REFUSAL OF PLANNING PERMISSION

APPLICATION NO. 2020/0325

Proposal Conversion of (A4) Public House into 11 (C3) Apartments

At Horse and Groom, Barnsley Road, Goldthorpe, Barnsley, S63 9NE

Project The Horse and Groom, 38 Barnsley Rd, Goldthorpe, Rotherham S63 9NE				
Title Proposed conversion of a public house				
Scale @ A0 1:50/100	Date Jan 2020	Ref 063	Drawn JSWR	Rev B
Dwg No 063/HGB/PL

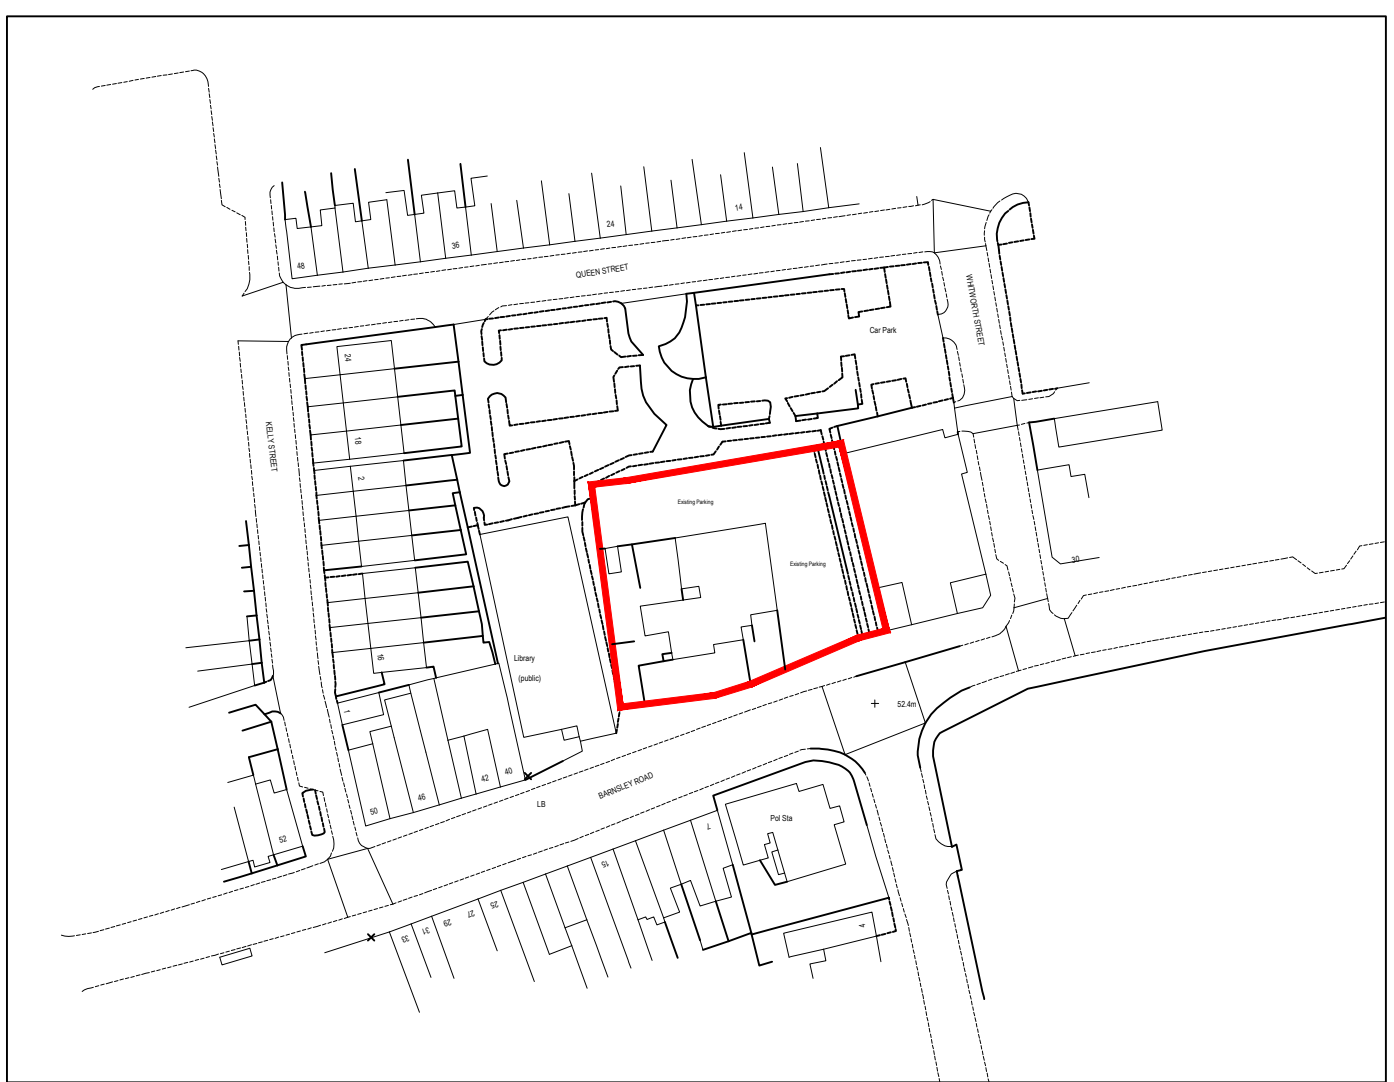
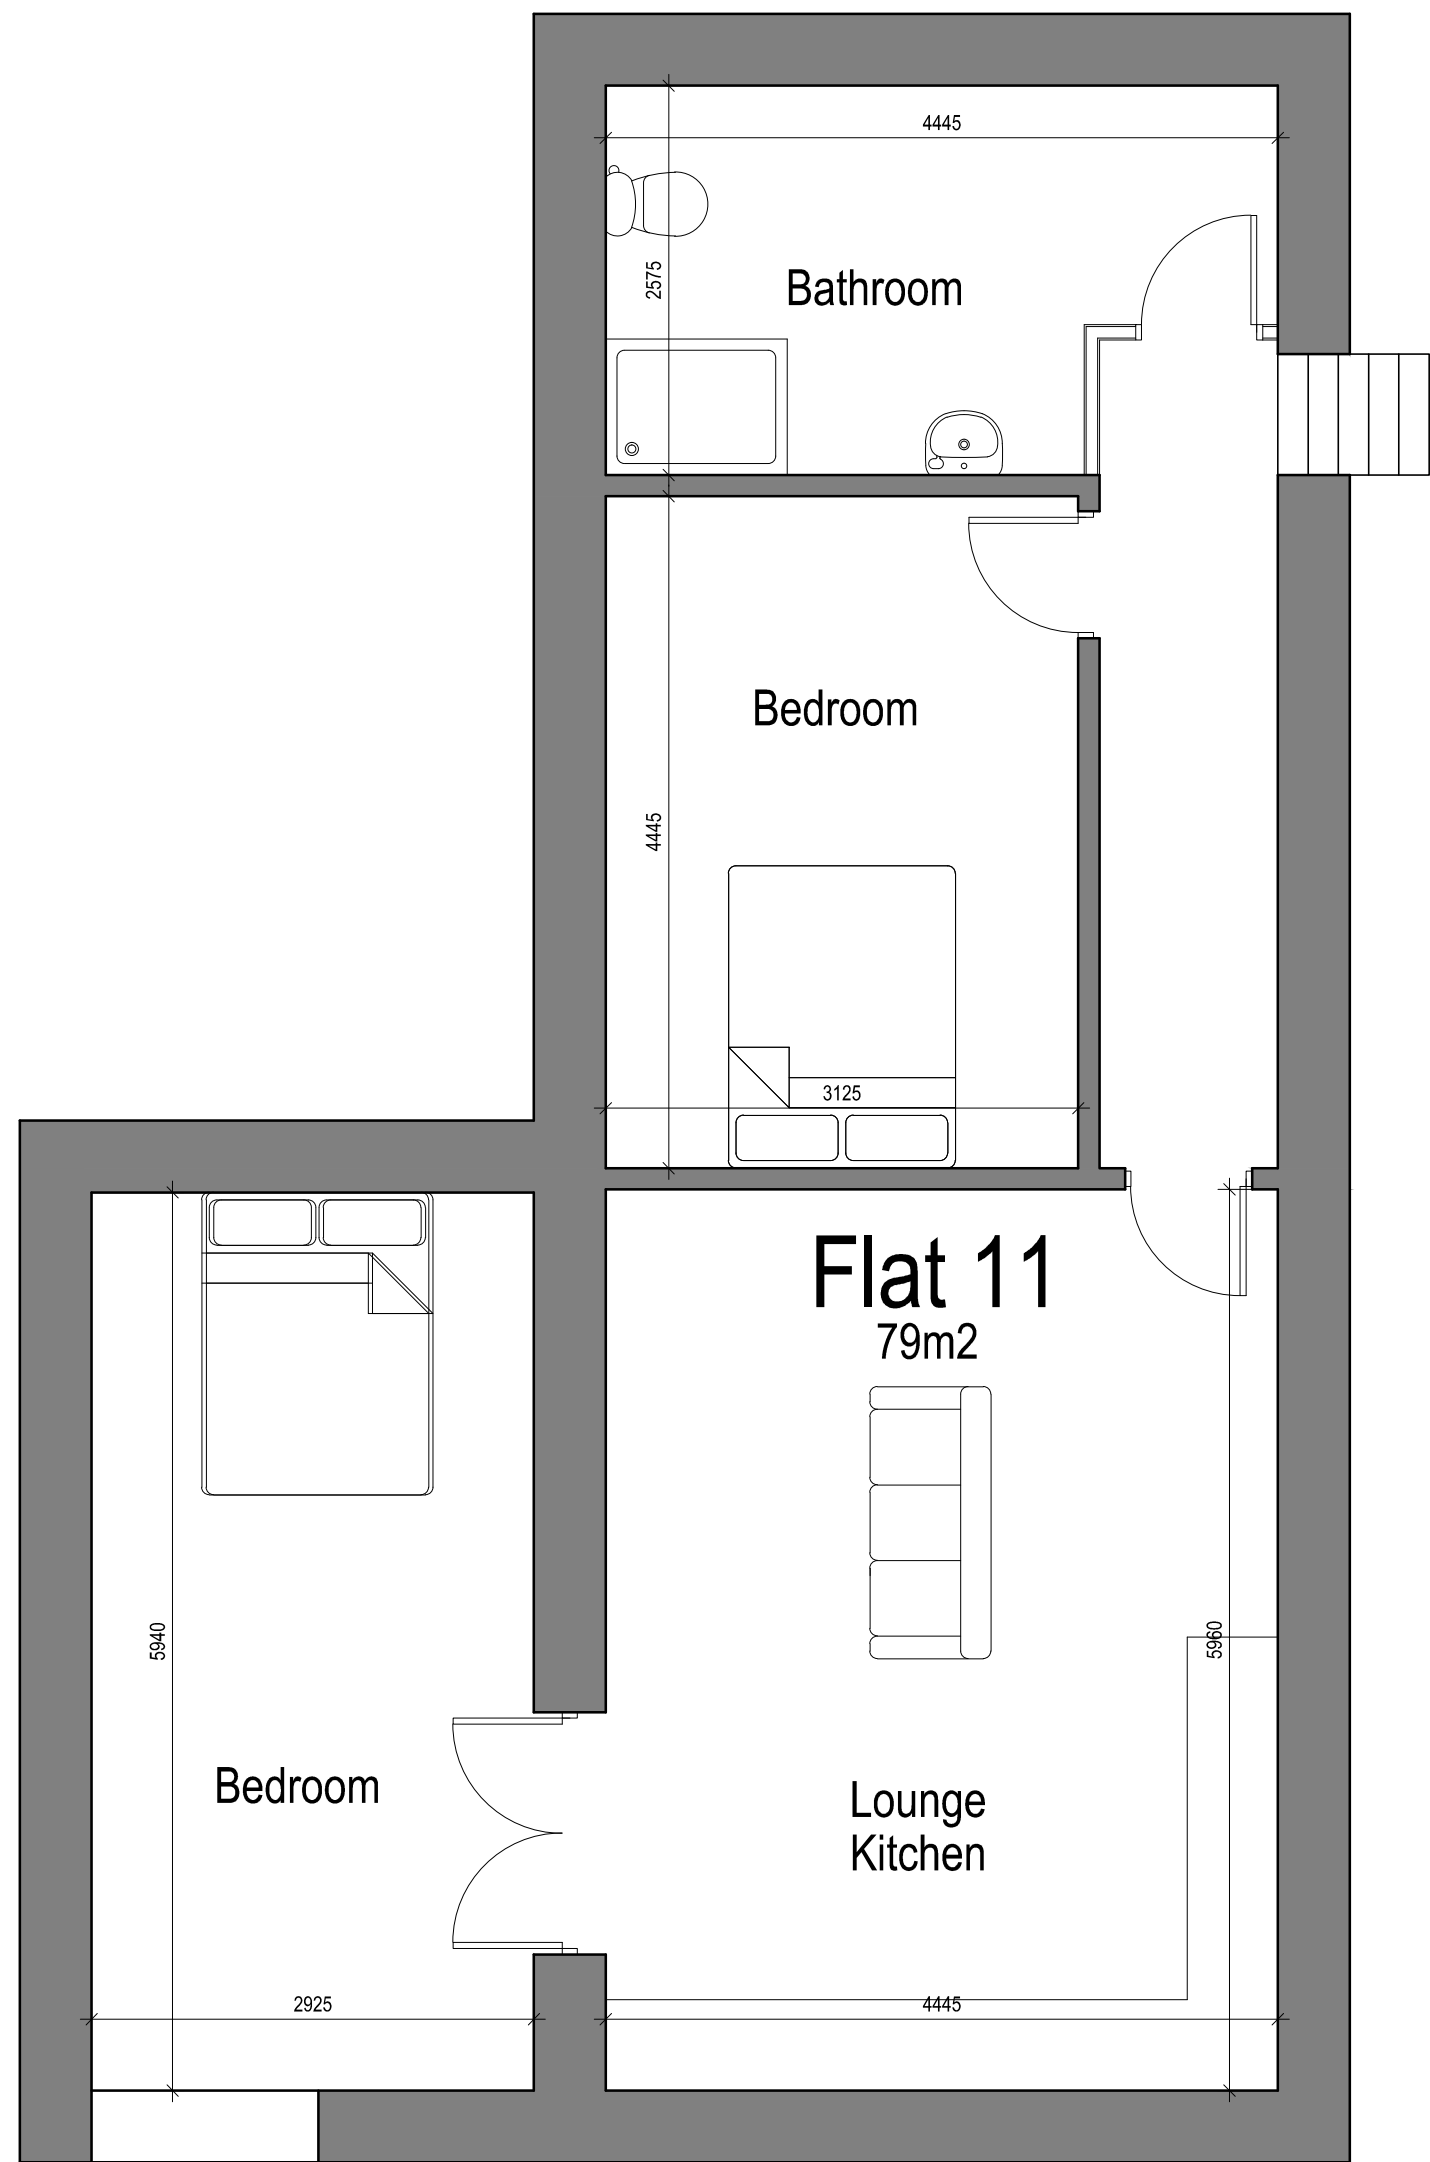
- 2 A number of the proposed room sizes and flats are not up to the minimum standards as expected within SPD: Design of Housing Development and the South Yorkshire Residential Design Guide (SYRDG). In the opinion of the Local Planning Authority, the proposed development does not provide adequate living and internal amenity space for future residents, contrary to SPD: Design of Housing Development and the SYRDG.
